RE: VA-21-00004 Hatcher Variance

Mike Flory,
Building Official

HATCHER

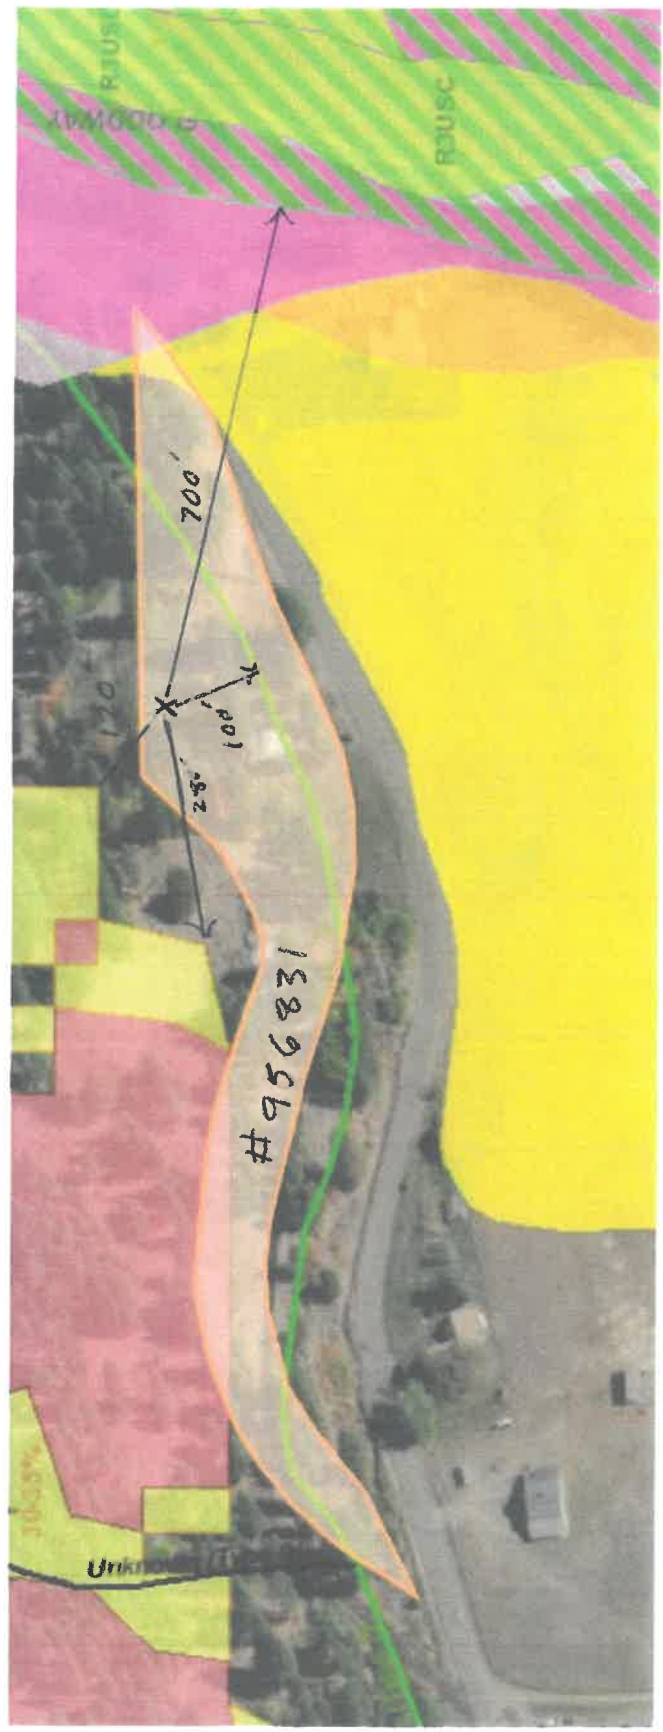
Both the 2018 International Residential Code and the 2018 International Building Code require a minimum of 5 feet setback to a property line for fire protection.

If the building setbacks are reduced, the structure would need to meet a minimum one-hour fire resistance rating from both sides, based on a U occupancy associated with an R-3 use. If this were a commercial use the distance and fire ratings will go up.

To keep things simple for the applicant and to help protect the neighboring property, I suggest a setback of no less than 5 feet to the property line.
